Project:	National Highways Spatial Planning Arrangement 2021-2024	Job No:	60659714 / Q11DDO009.003
Subject:	Land at M40 J11: Transport Assessment, TA Addendum and DMRB Review		
Prepared by:	Wasiq Ruwaisdeen & Senth Sivanathan	Date:	18th November 2022
Checked by:	John Paul Hipkin & Kim Petingill	Date:	6th December 2022
Verified by:	Liz Judson	Date:	14th December 2022
Approved by:	Andrew Cuthbert	Date:	20th December 2022

AECOM have conducted a review, on behalf of National Highways (NH), of the Transport Assessment (TA), and a TA addendum prepared by David Tucker Associates (DTA), on behalf of Greystoke, prepared in support of a planning application for a proposed B8 development located at Land at M40 Junction 11, Oxfordshire. The TN will also undertake a DMRB Review of the proposed mitigation proposals at M40 J11. Following this review, AECOM make the following recommendations.

JOB TITLE		LAND AT M40 J11		CLIENT		GREYSTOKE	
DRAWING TITLE							
M40 Junction 11 Gyratory							
SCALE	DRAWN BY	DATE	DRAWING No	REVISION			
1:1000@A1	RM	04/10/22	23459-06-02-GA	A

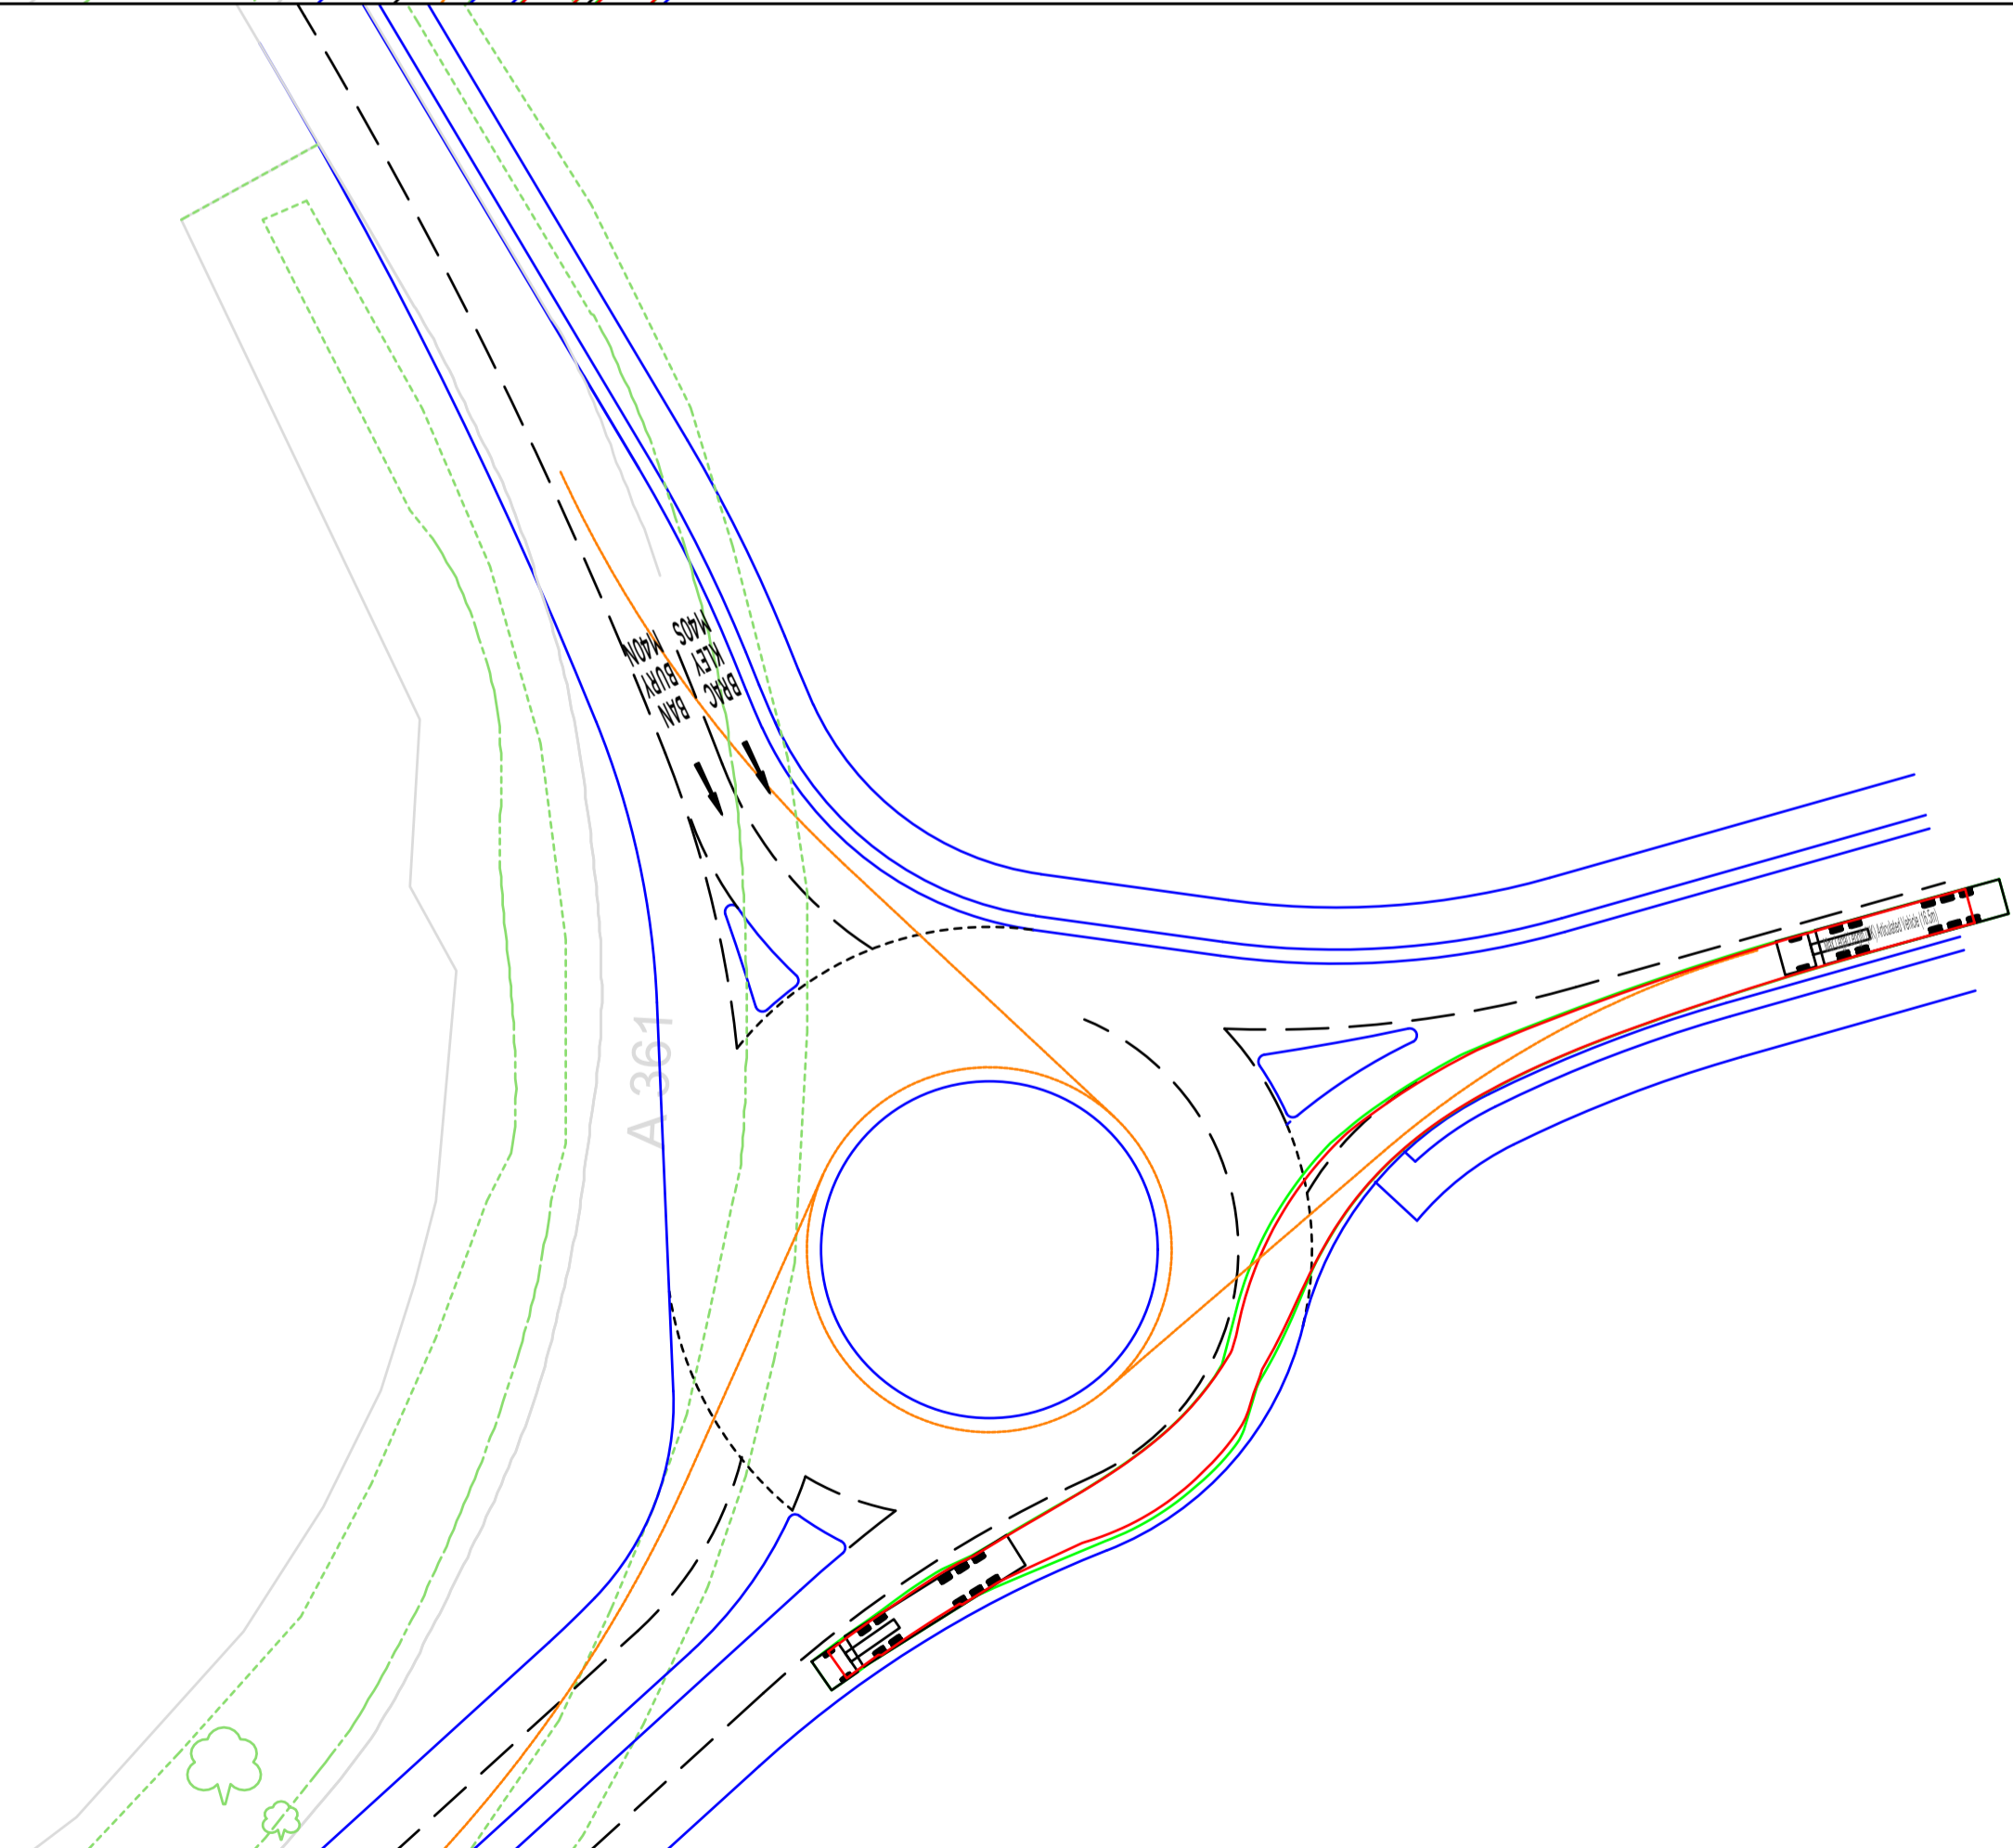
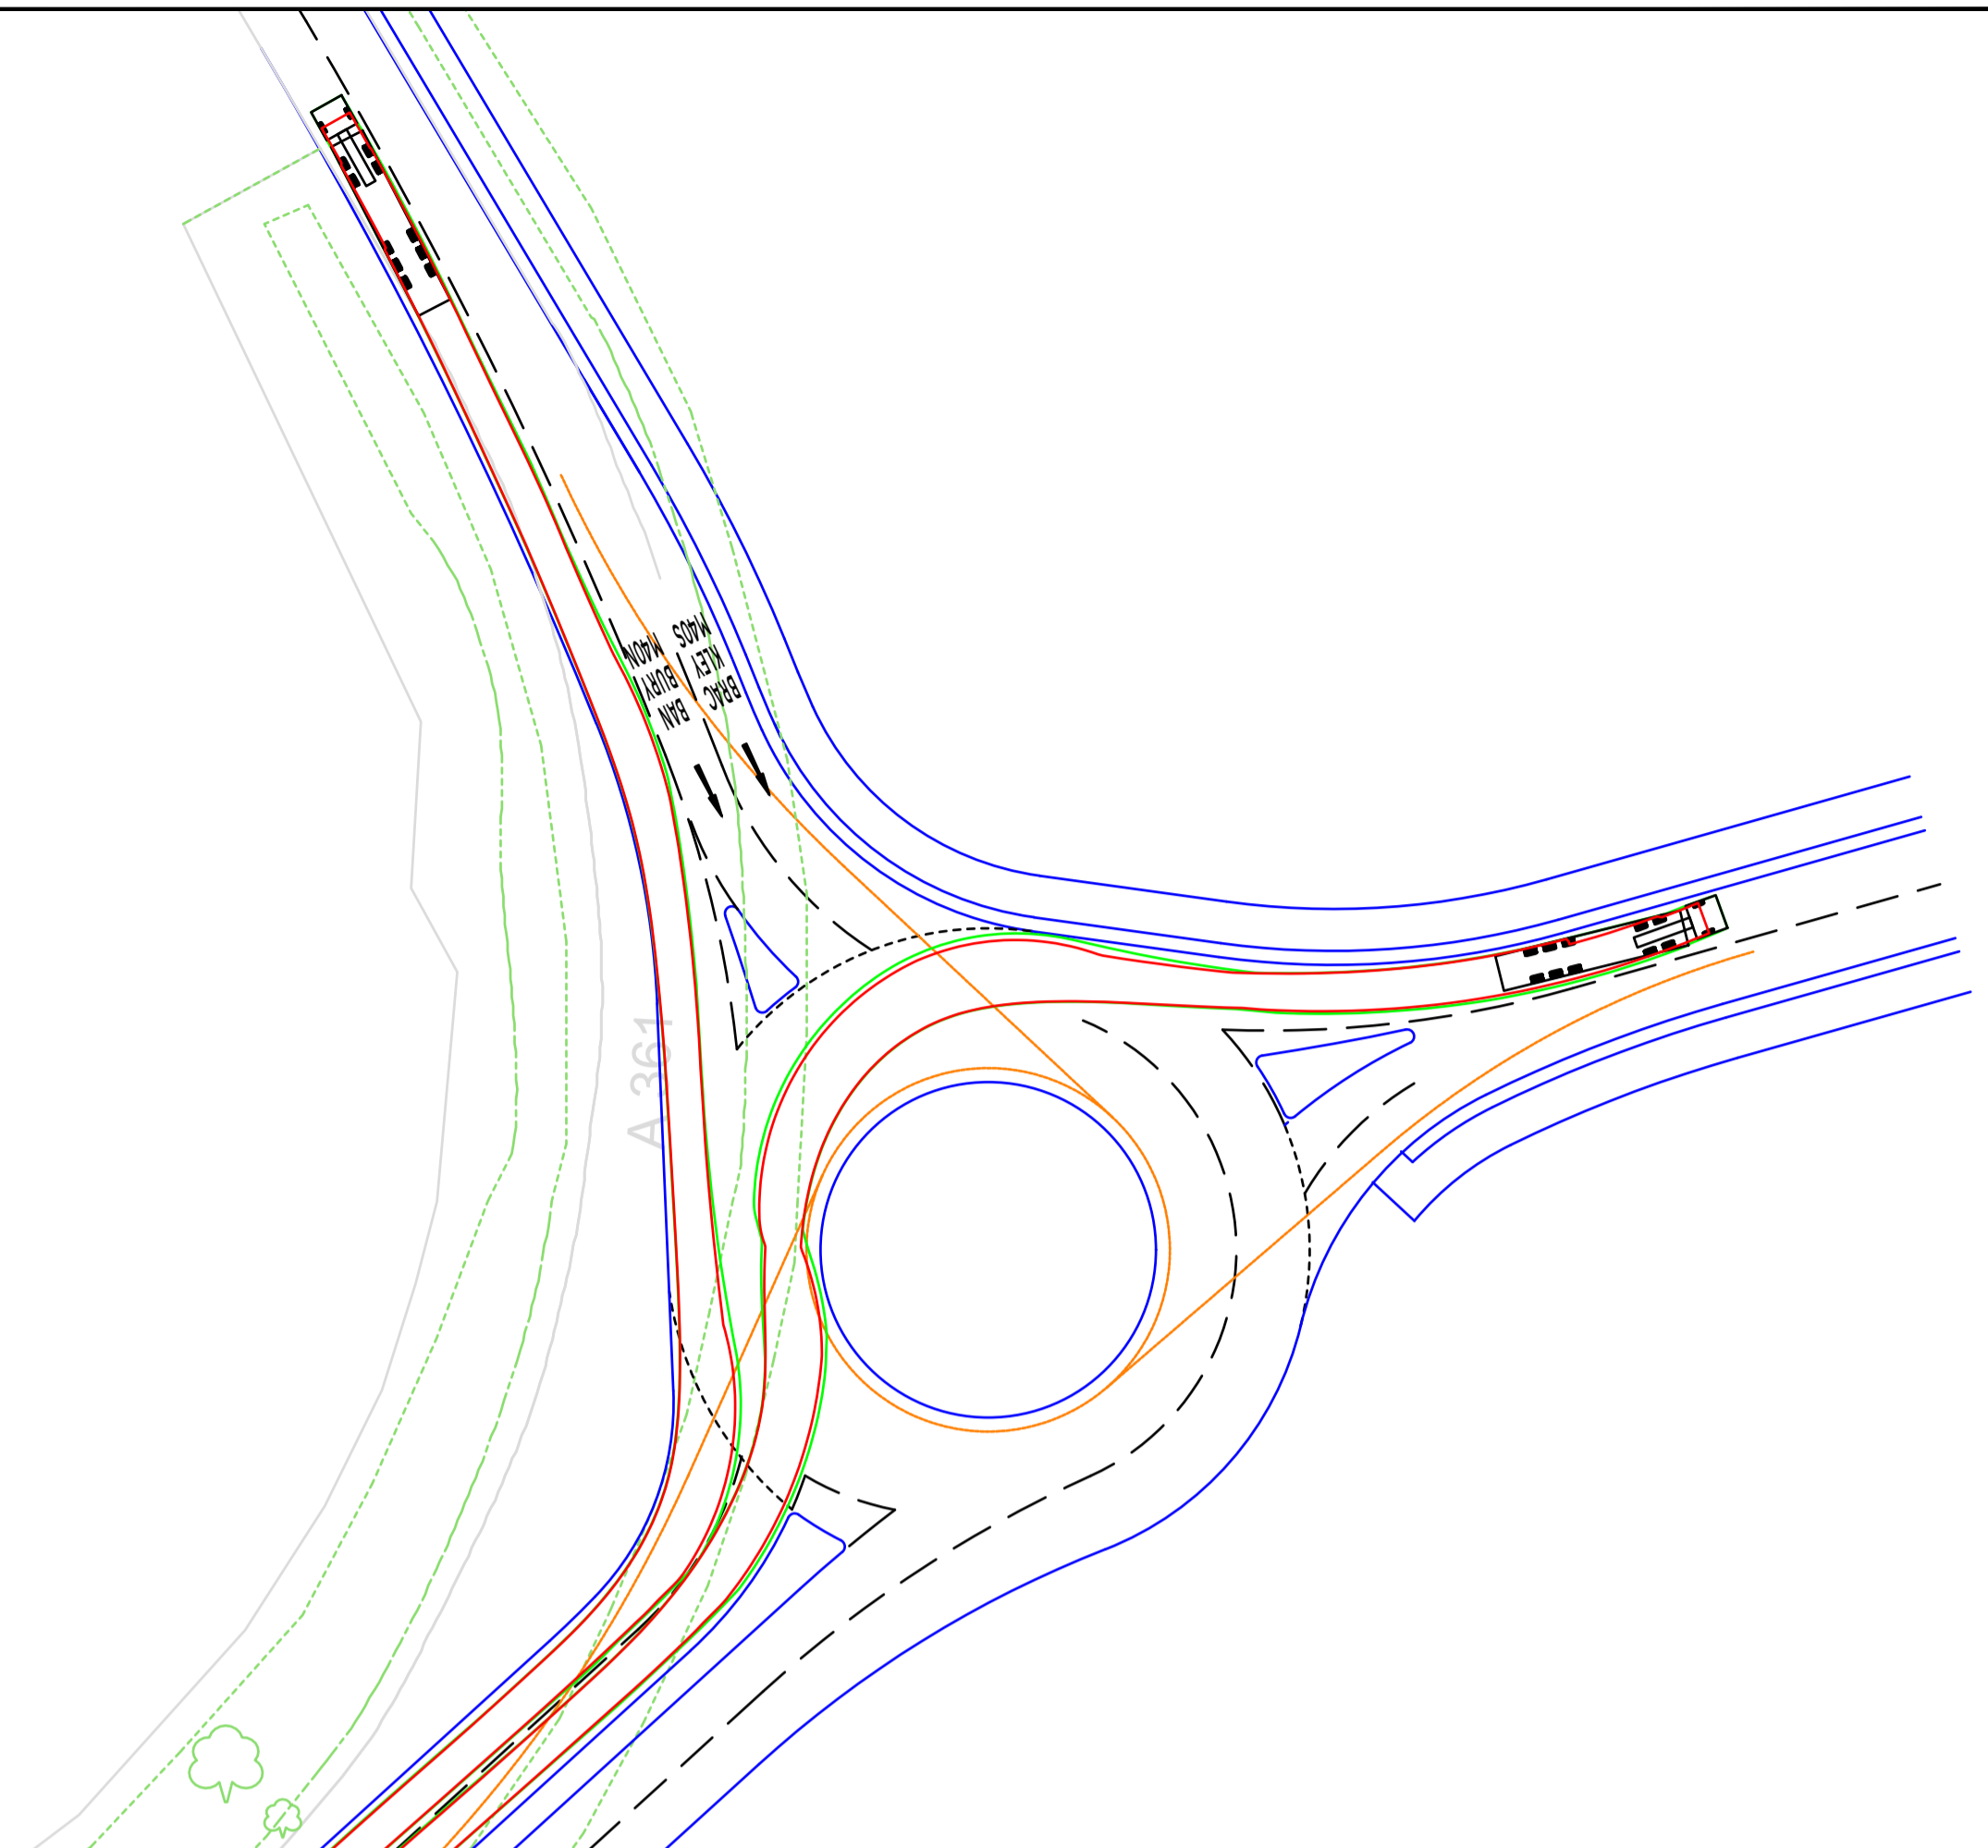
4. The reasoning behind HGV PCU factors should be provided. (Para 8.6)
5. With regard to the introduction of a short flare on the approach to the circulatory stop line on the westbound overbridge. The verge, earthworks and the 70m approach visibility to the signal heads should be clearly illustrated. The safety implications of felling mature trees so close to the edge of the Motorway should be taken into account in any construction management plan. (Para 11.16)

13. The visibility to the circulatory signal heads have not been illustrated on the drawing. There appears to be no reason why these visibility splays should not be achievable. It is recommended that these should be provided in accordance with CD 116 and illustrated on future revisions of the drawing. (Para 11.15)

14. With regard to the introduction of the short offside flare on the westbound overbridge. There is a concern that it may not be long enough to accommodate a full-sized HGV without the nearside rear corner of such a vehicle protruding into the middle lane and presenting a hazard to a car in the middle lane trying to get to the stop line. It is recommended this issue is addressed. (Para 11.17)

15. The proposed mitigation measures at M40 Junction 11 should be reviewed with regard to CD116, and illustrated/ annotated on an updated version of the drawing, to include:

- Entry kerb radius;
 - Entry angle;
 - Lane Widths/ Entry width/ Exit width; and
 - Entry path radius/ deflection. (Para 11.18)
16. Advice should be sought from the Safety, Engineering & Standards (SES) group within National Highways as to whether a Departure from Standards application would be required in respect of these existing features, if any of them are found to be substandard. (Para 11.19)

18. All primary signal heads should be shown to be located a minimum of 1m from the stop-line and the proposed locations for the secondary signal heads for the circulatory approach are illustrated on subsequent versions of the layout drawing and/or its successors in title. (Para 11.21)

19. The locations of the signal heads controlling the circulatory carriageway at the M40 northbound slip road entry should be illustrated on subsequent versions of the layout drawing and/or its successors in title and the visibility splay to the signal head shown. (Para 11.22)

20. The proposed locations for the traffic signal controller cabinets should be illustrated on subsequent versions of the layout drawing and/or its successors in title and that the controller cabinets are positioned accordance with TSM advice. (Para 11.23)

21. The intervisibility zone for the proposed signals should be illustrated on subsequent versions of the layout drawing and/or its successors in title. (Para 11.24)
